WINSOME FILING NO. 2 CONSTRUCTION DOCUMENTS

EPC STORMWATER REVIEW COMMENTS ARE SHOWN IN ORANGE BOXES WITH BLACK TEXT

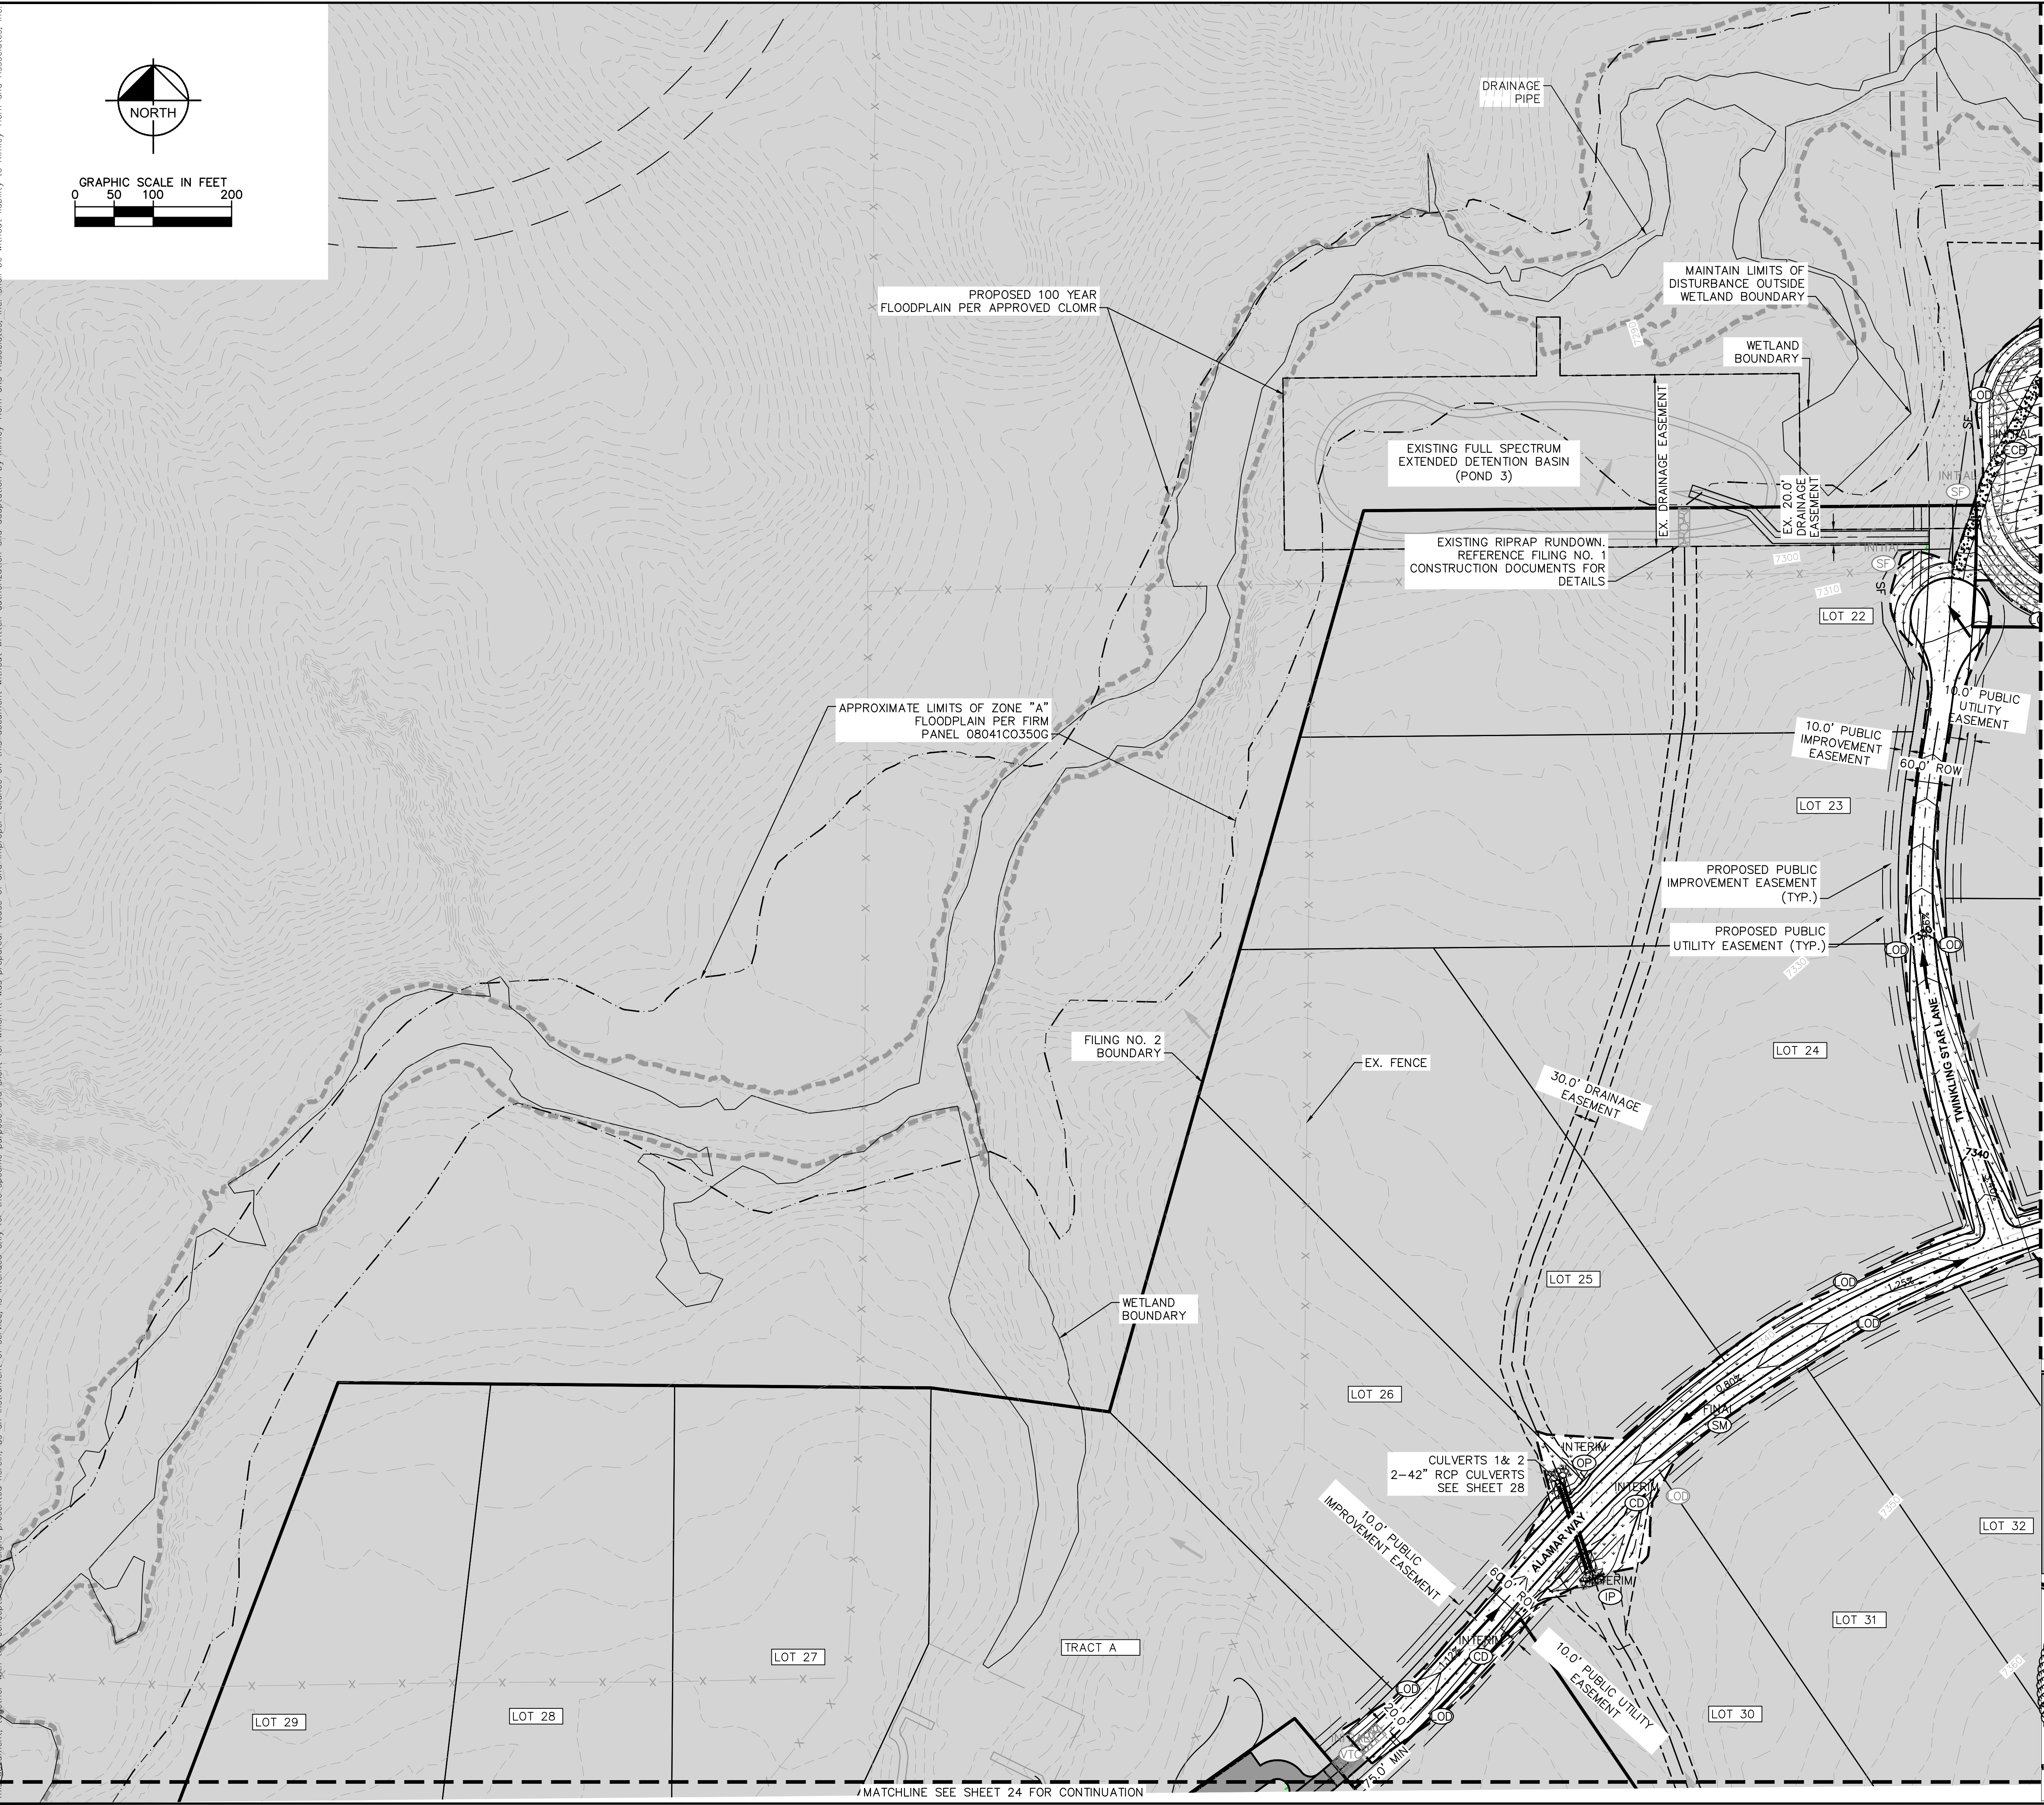
continue silt fence
